**KIRKLEES METROPOLITAN COUNCIL
INVESTMENT & REGENERATION SERVICE**

Reference No:	2023/70/92163/W
Site Address:	Holmroyd Nook Farm, Knoll Lane, Netherthong, Holmfirth, HD9 3UR
Description:	Variation condition 2 (plans and specifications) on previous permission 2010/93437 change of use of barn to dwelling with alterations and extension to Listed Building, replacement of stable block with garage/home office to amend the height of the development
Recommending Officer:	John Holmes

DECISION – Approve Variation of Condition

Report Dated: 5th September 2023

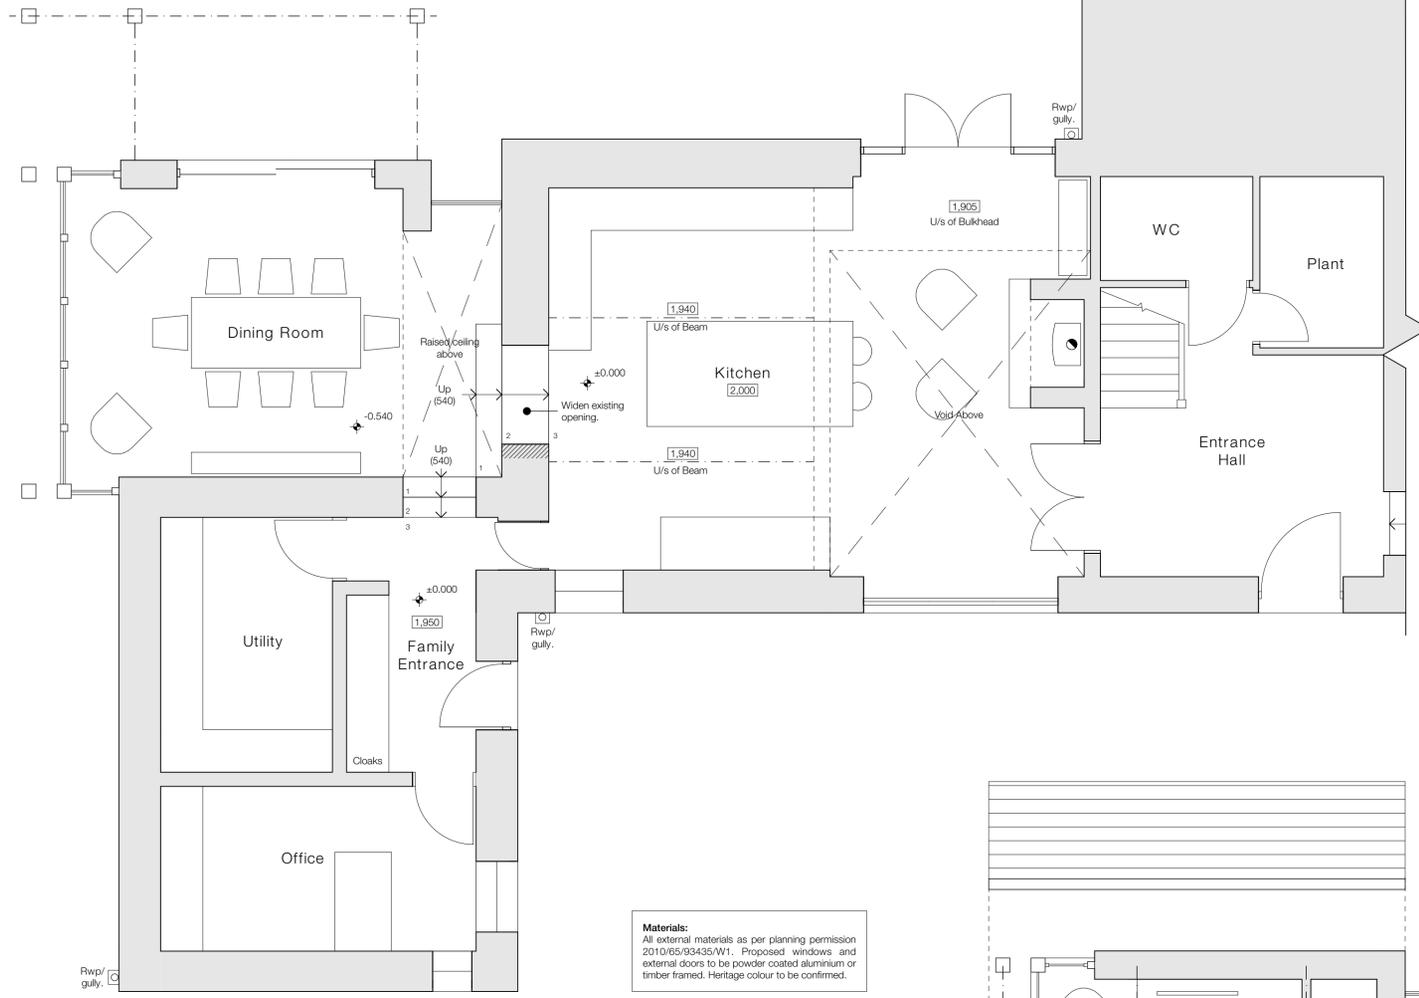
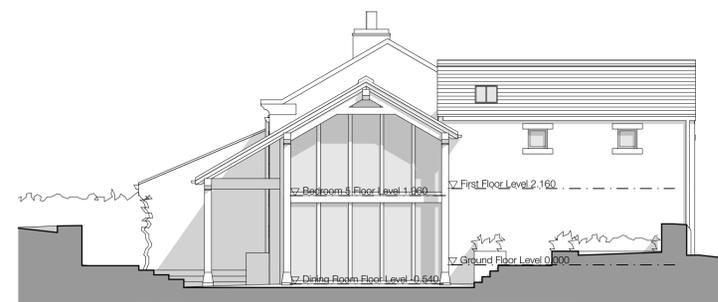
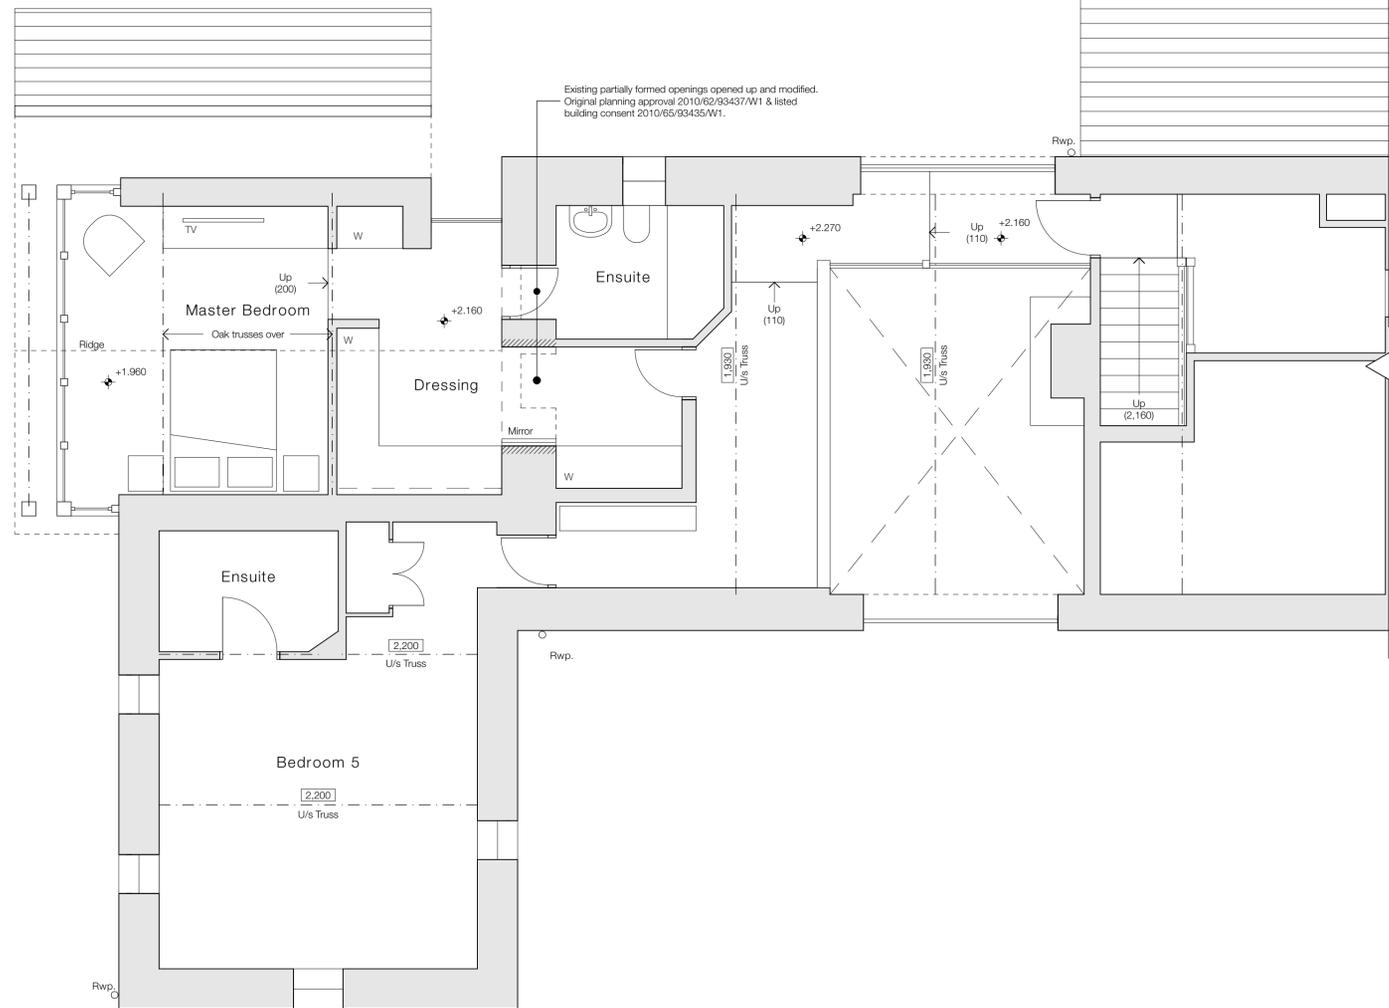
As such the principle of the development is considered to have been established by the previous permission. The proposal would see drawing no. 09096D-04-P01 replaced by submitted drawing 3429(0-) 07.

The proposed replacement drawing makes marginal amendment to the scheme as approved and would see an increase in the ridge height of the extension element of the approved scheme from 5.3m to 5.9m.

The proposal incorporates a mix of glazing, masonry / render and stone tile roof with one elevation consisting of a glazed wall. The materials of construction are detailed upon the submitted drawing as being to be in keeping with those of the 2010 application.

It is recommended this condition remains as worded (with the reason updated to reflect the now applicable local / national policies), and the plans table upon the decision be updated to reflect the fact the proposal relates to drawing 3429(0-) 07 rather than drawing 09096D-04-P01.
